Review Response

Project Name: McMillan Dock Repair

Response To: SHL23-035 SUB3

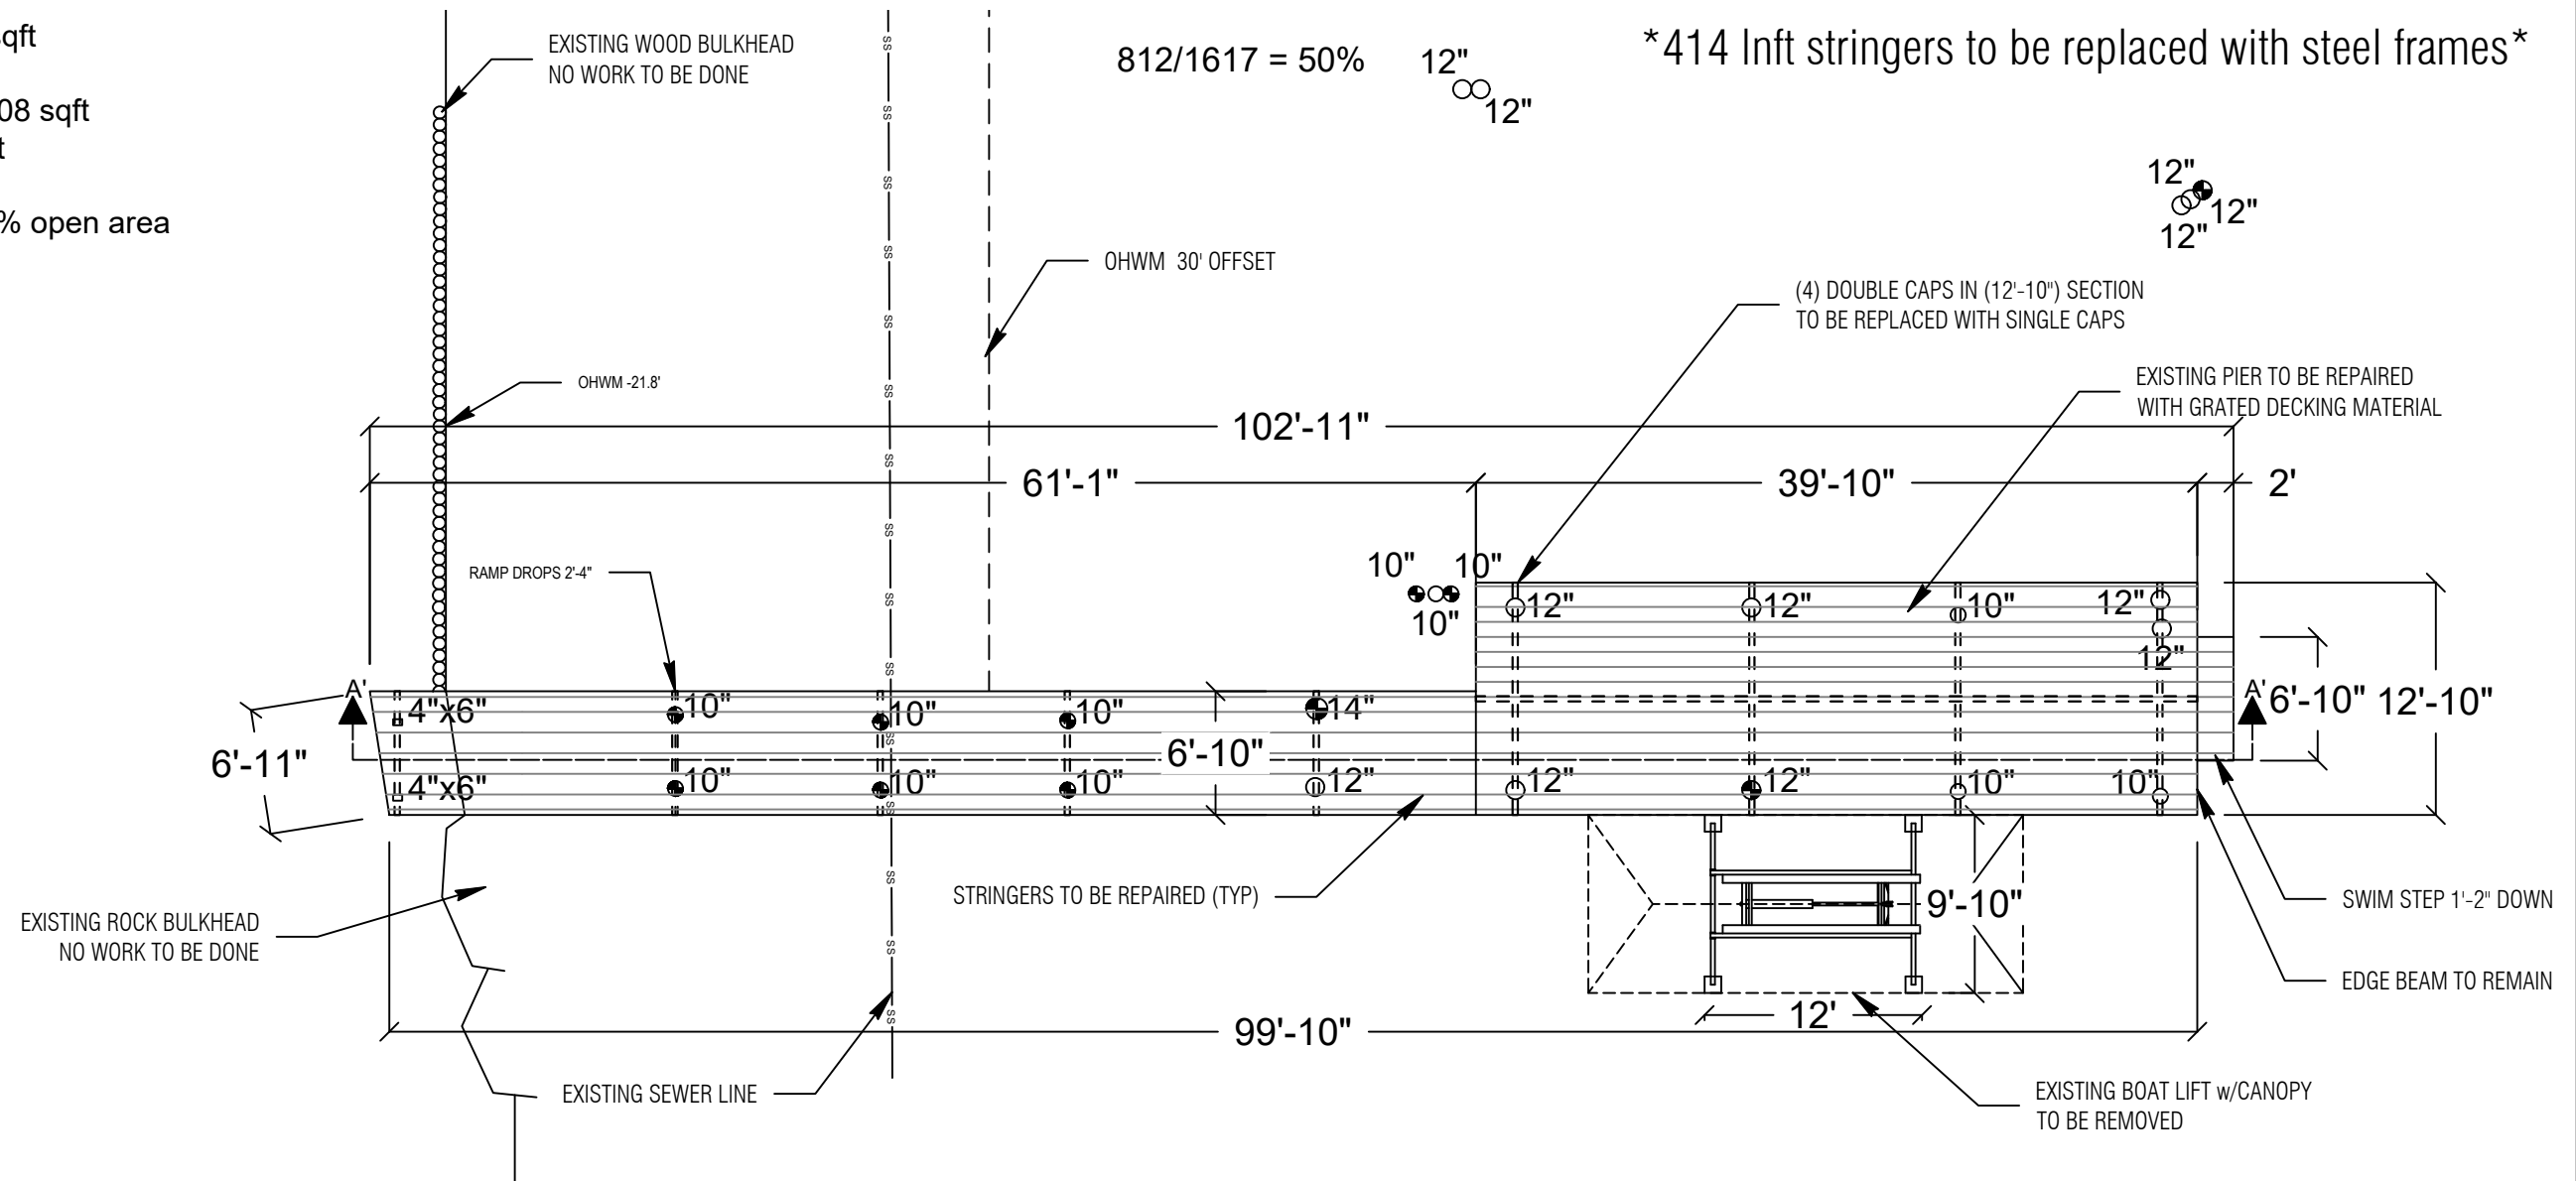
1. All caps to be repaired are highlighted with dashed lines, double caps repaired with single caps accounting for the reduction in Inft.

Piles to be repaired are hatched, identified in the legend.

All stringers are to be replaced with steel frames accounting for less than 50% off the Inft of material replaced. Stringers to be replaced are shaded gray and called out in legend (all stringers)

The 13 Inft edge beam to remain is called out on the plan.

See legend and hatching on updated plan set.

SHEET
6.0
 NWS-2023-XXX
 PAGE 6 OF 10

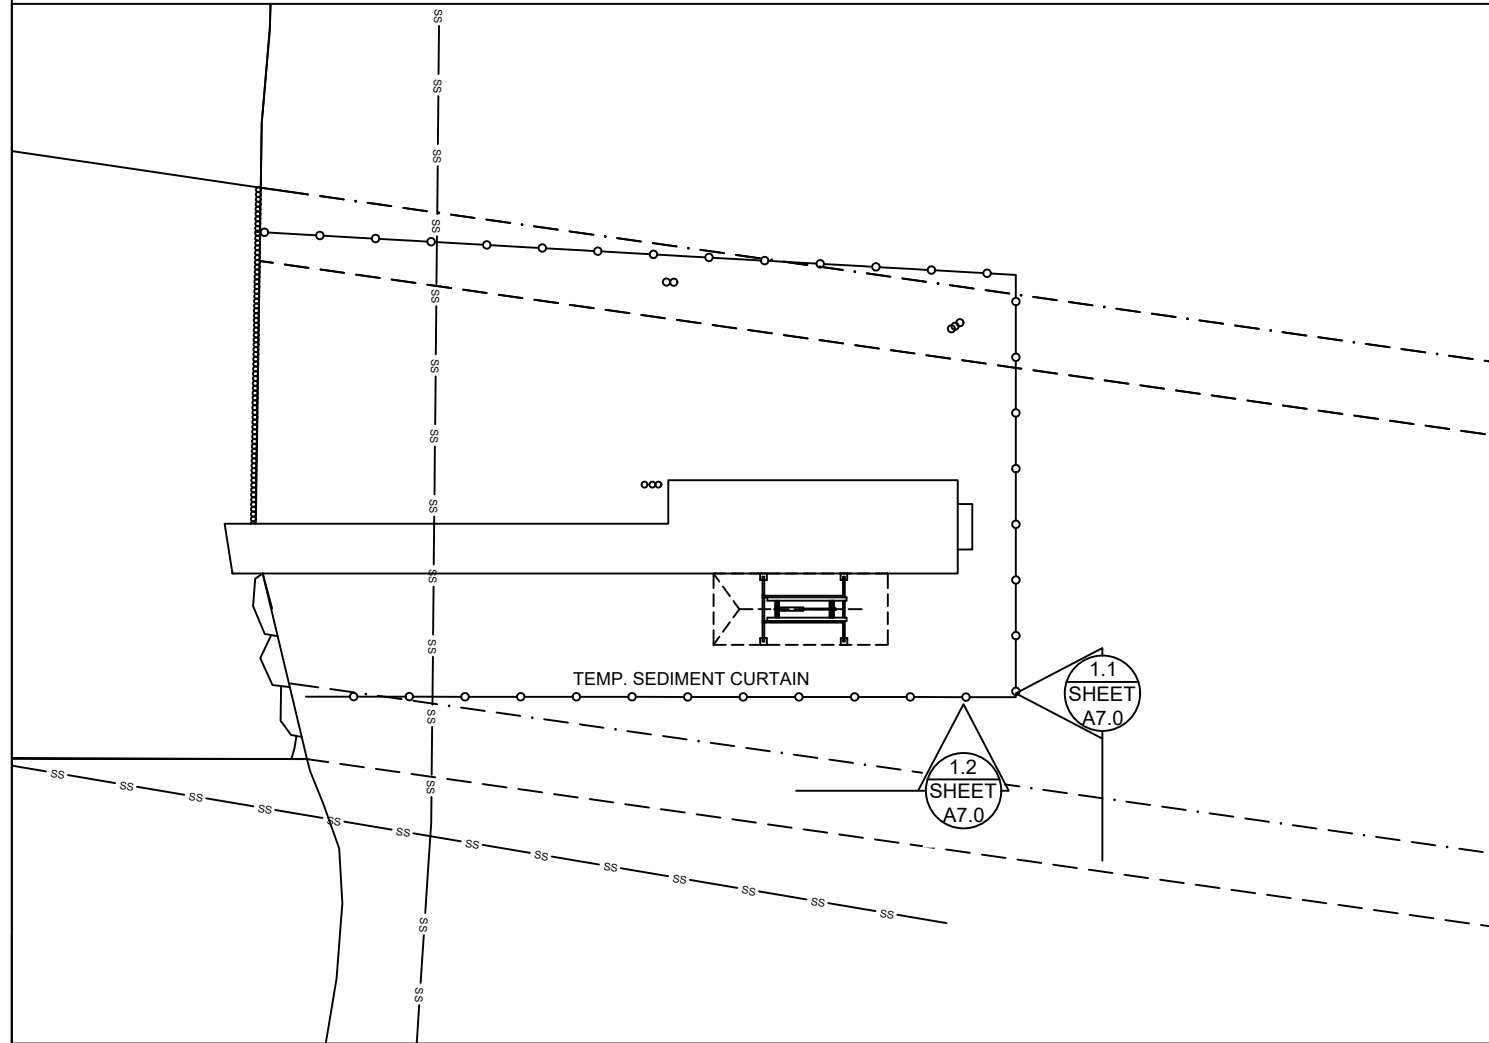
2. All piles to be repaired are highlighted on the plan set and in the legend.

Existing Inft is based on surveyed pile depth, see sheet 6.

Repaired pile Inft is based on the surveyed pile depth at locations of repairs, see sheet 6
